RE: 68 Commercial Street BP#2015-01114 plan review comments

The following are responses to your comments regarding the Code Analysis found on A1.01- Life Safety Plans for the Maine Wharf Interior Fit-Up for the Portland Science Center.

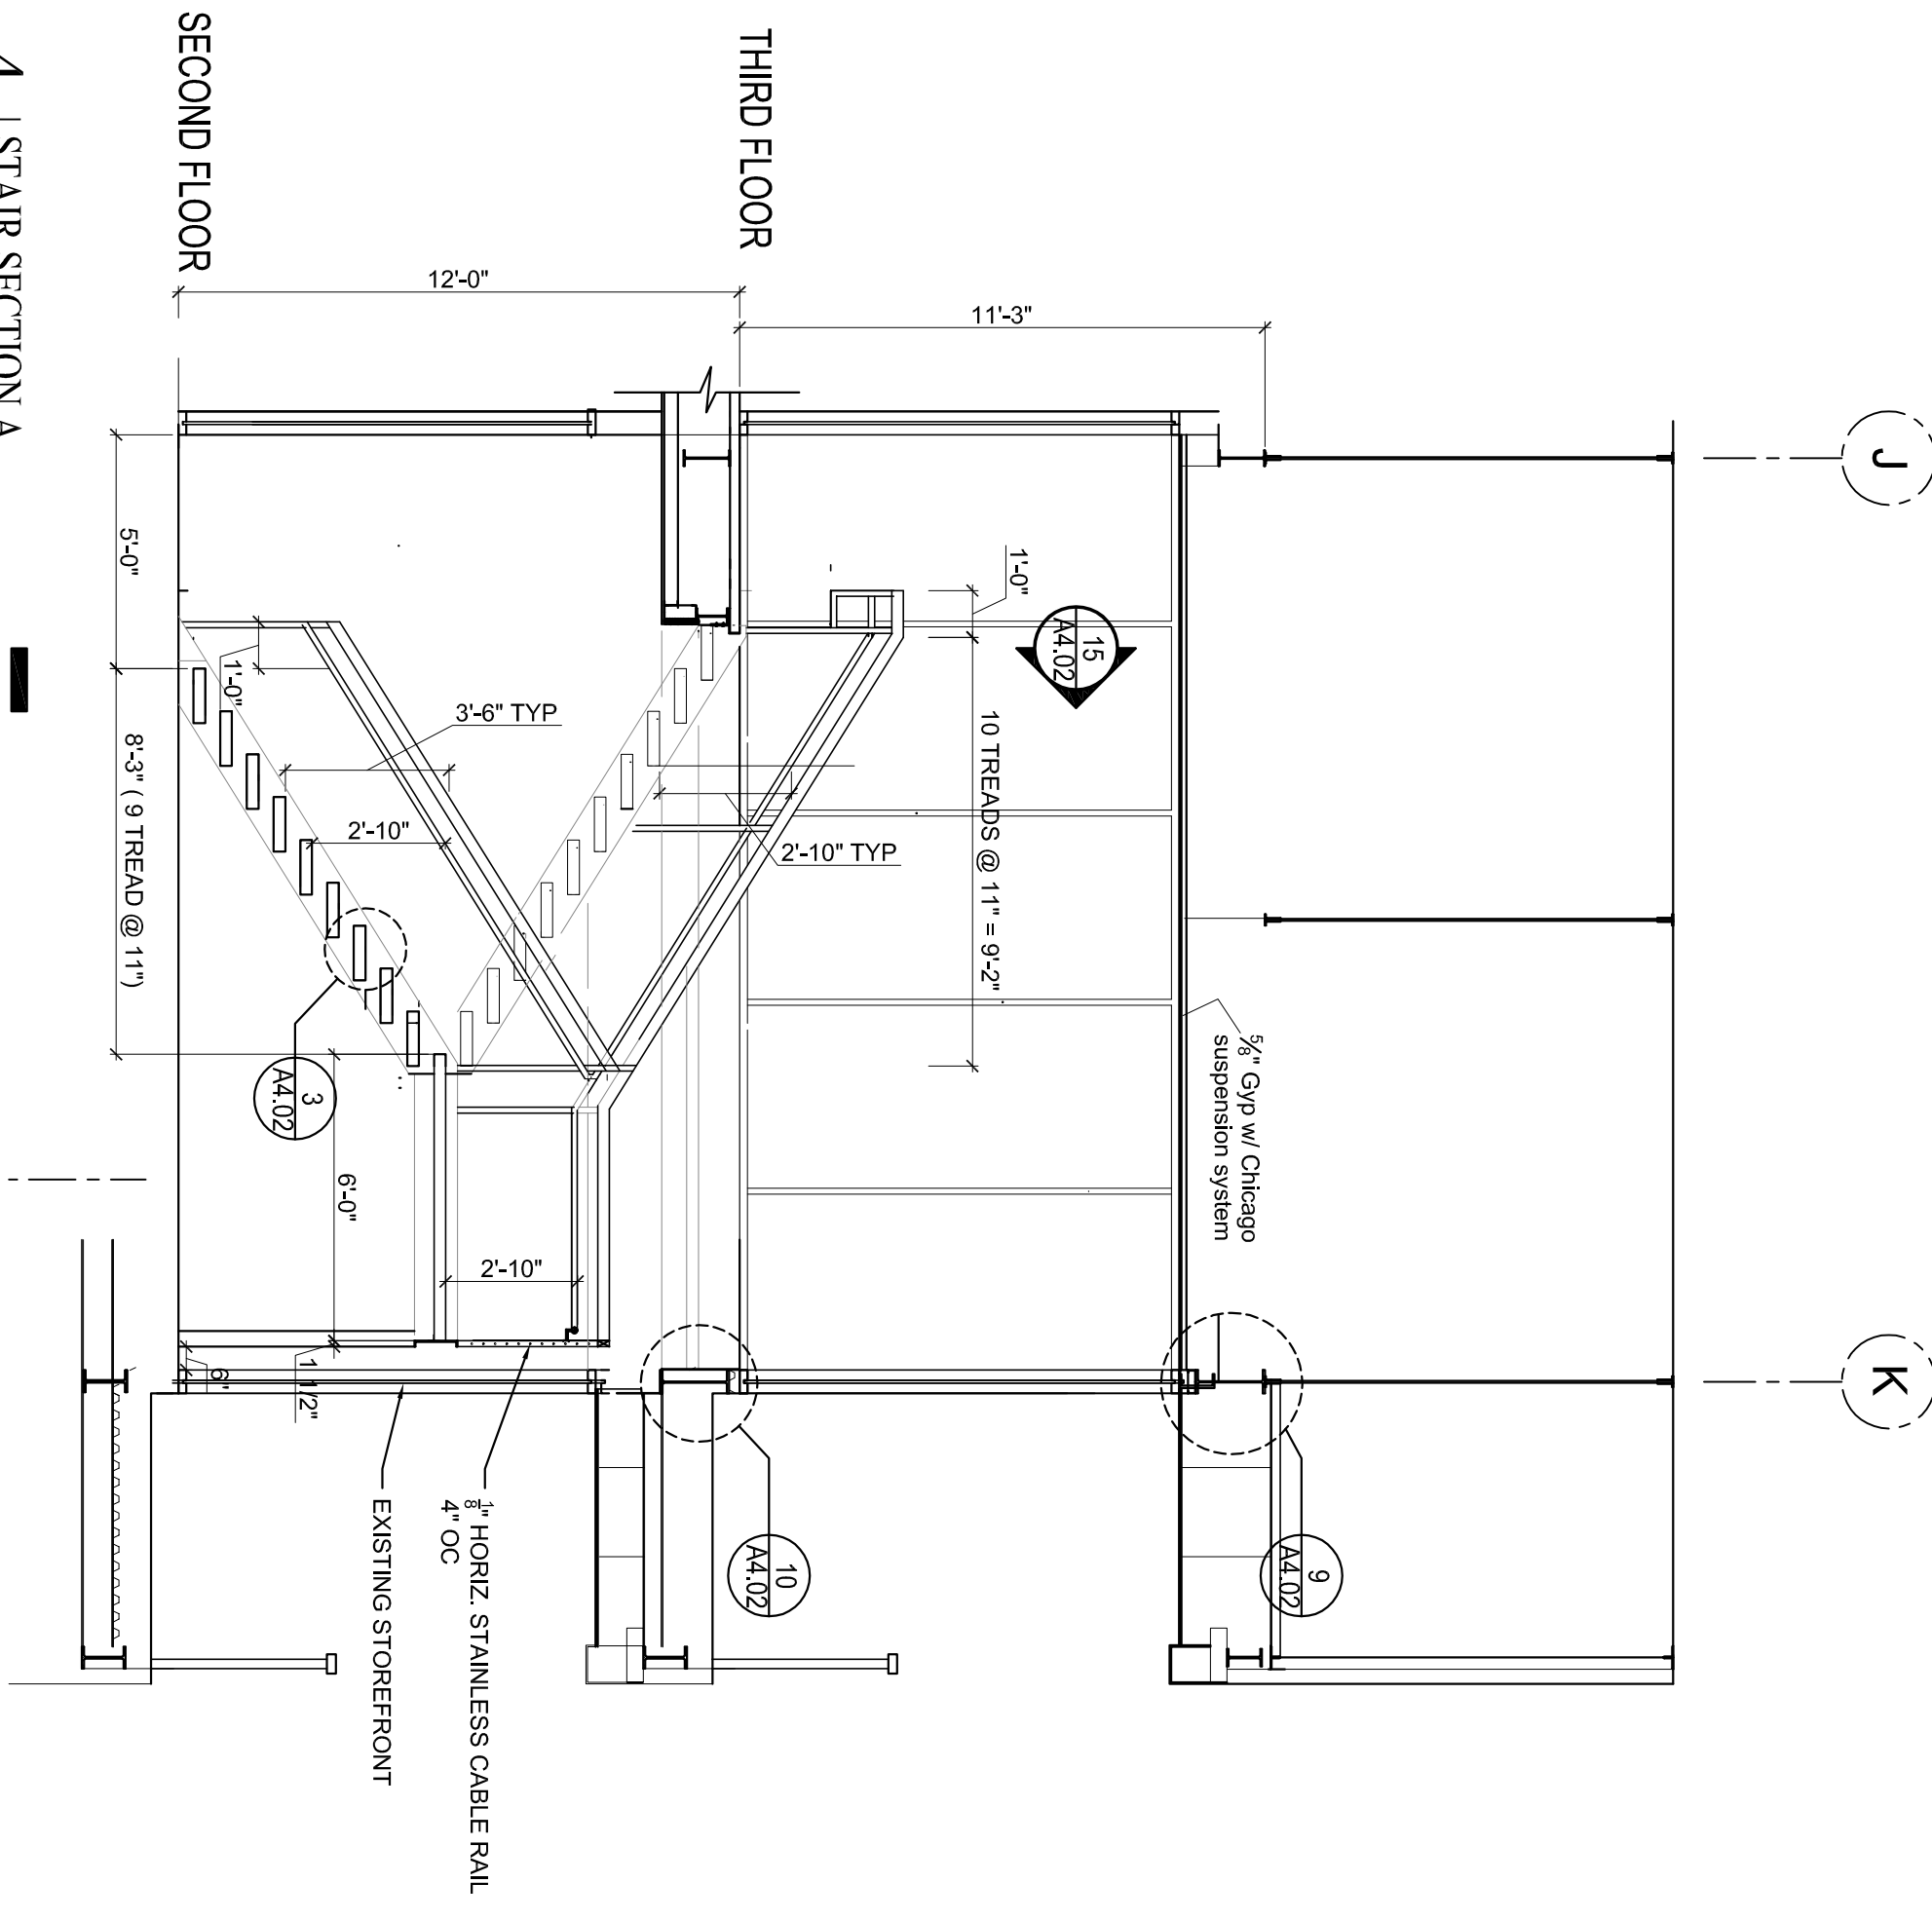
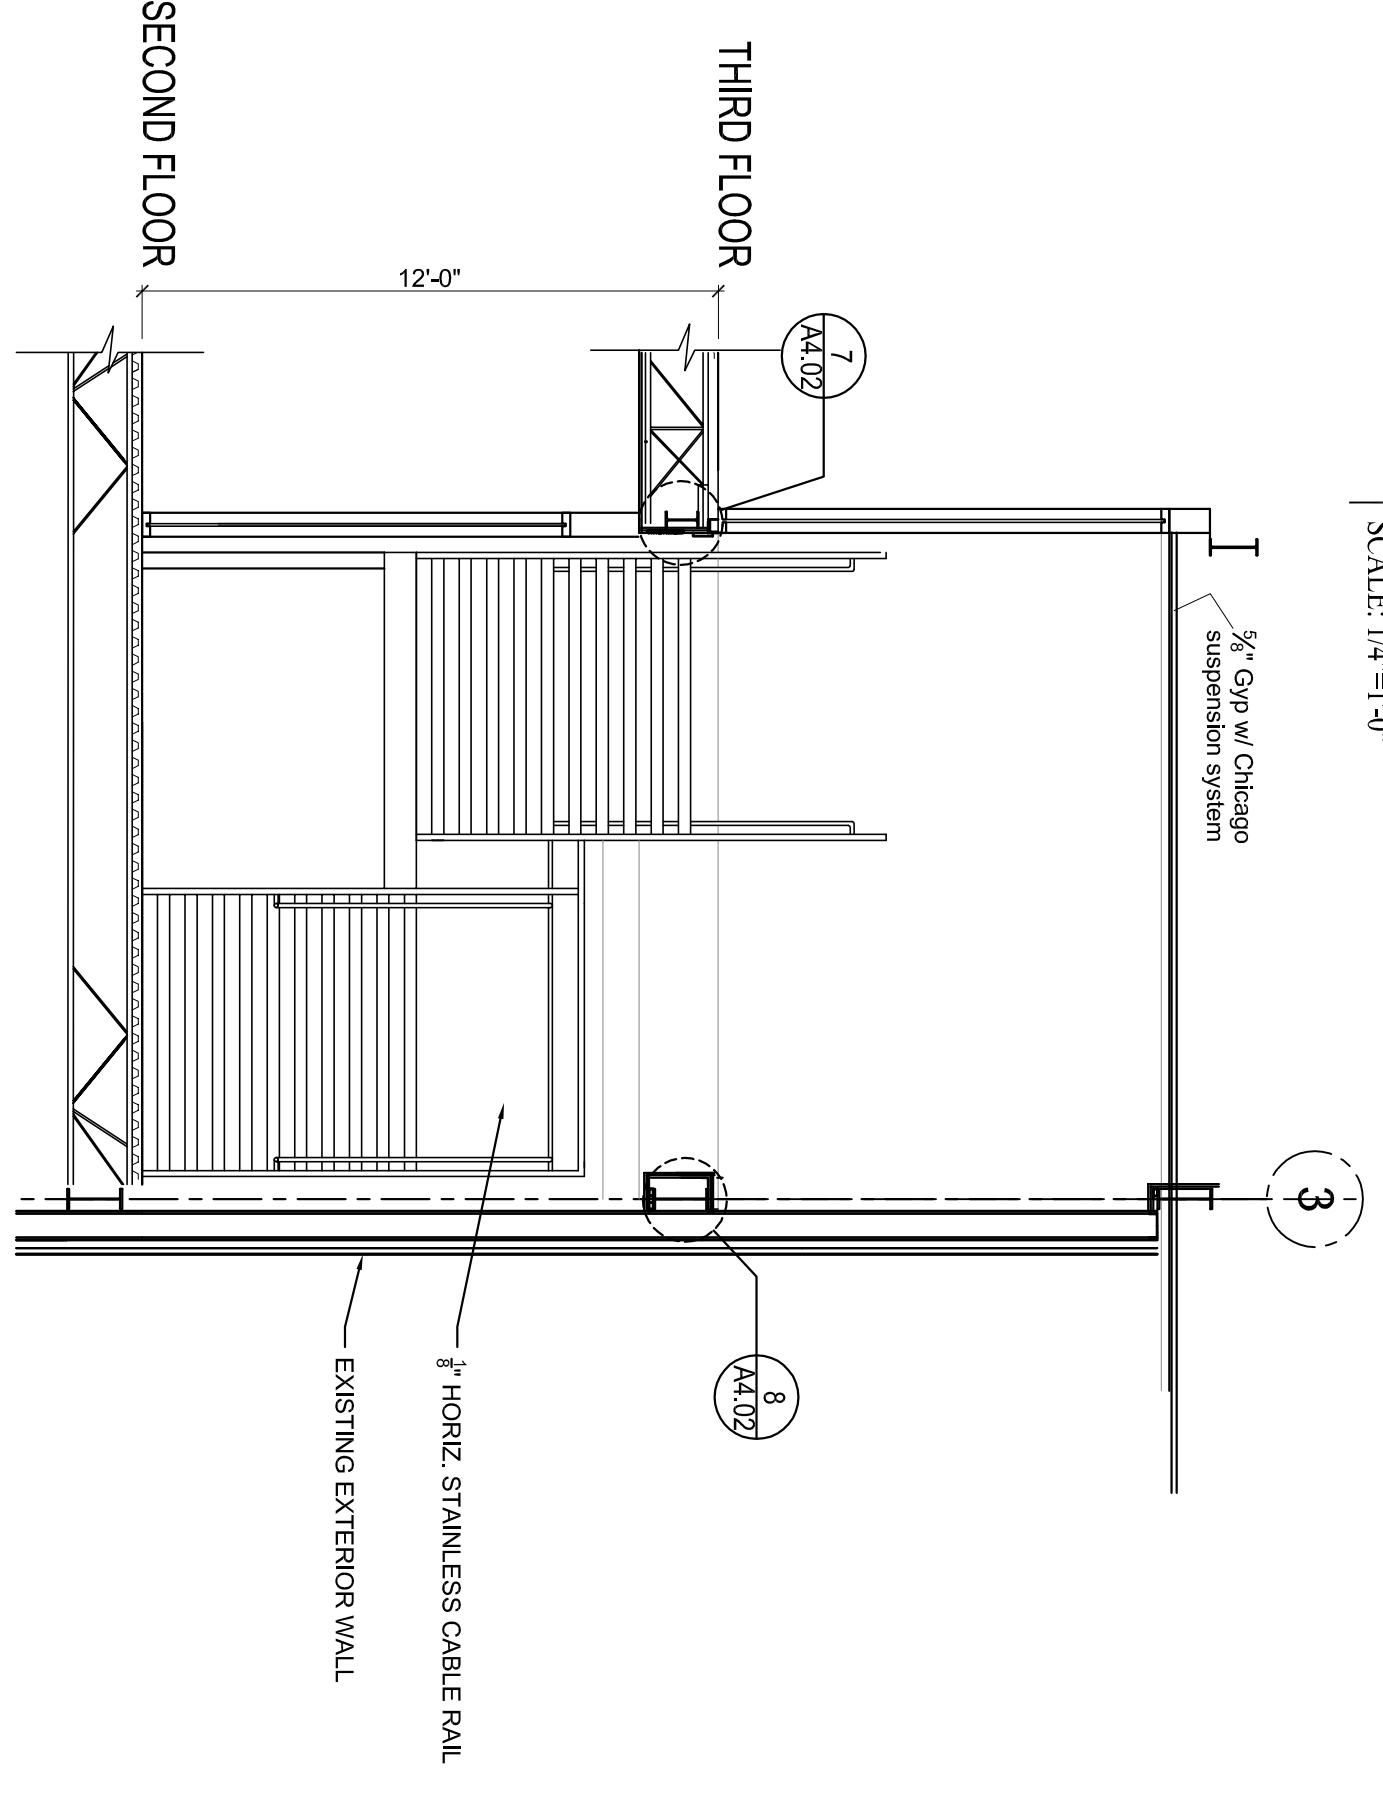
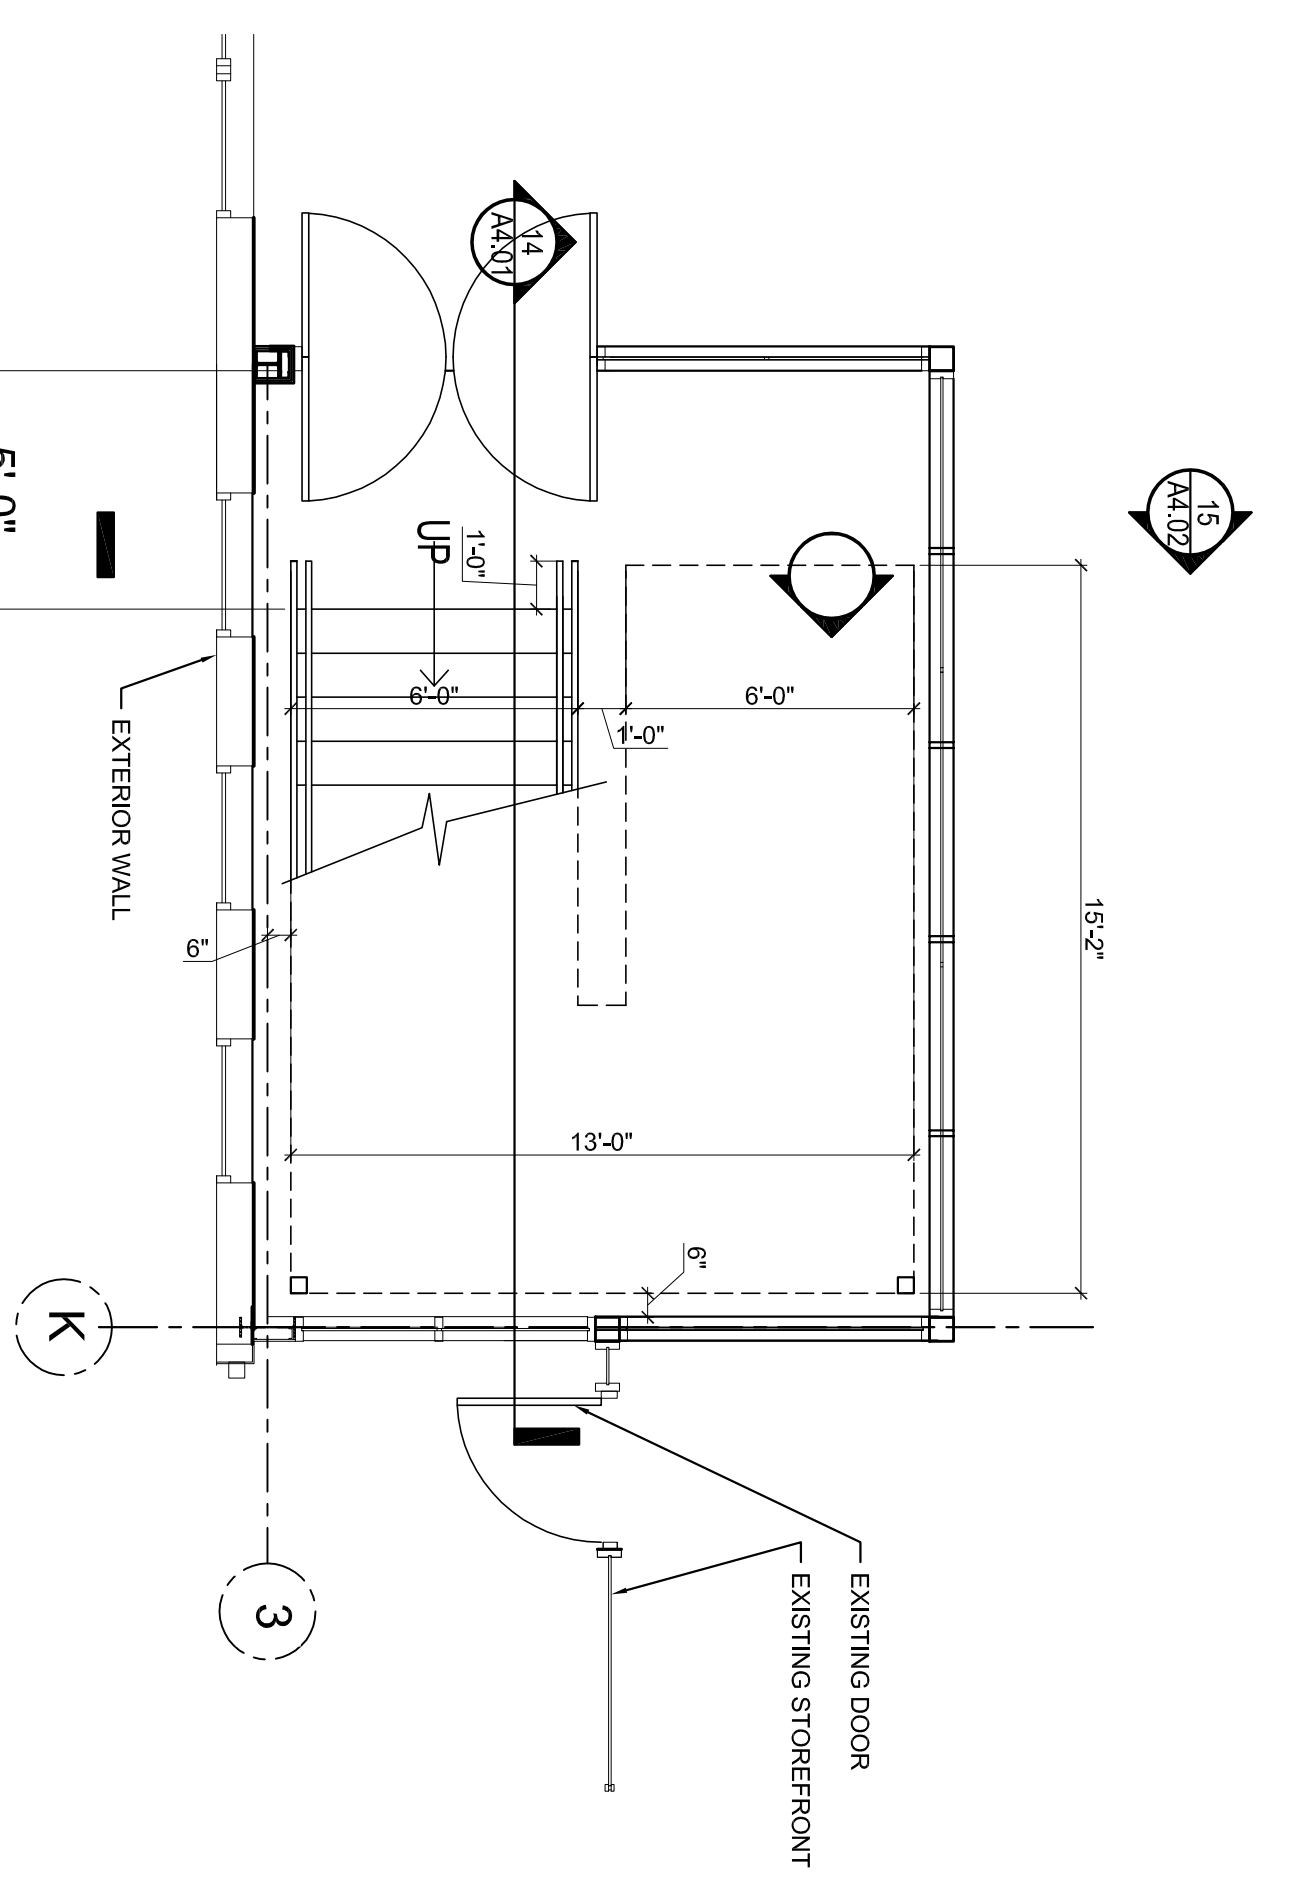
-The open stair connecting the second to the third floor is being proposed as an exit access stair. Because it has a clear width of 60", no intermediate rail is required.
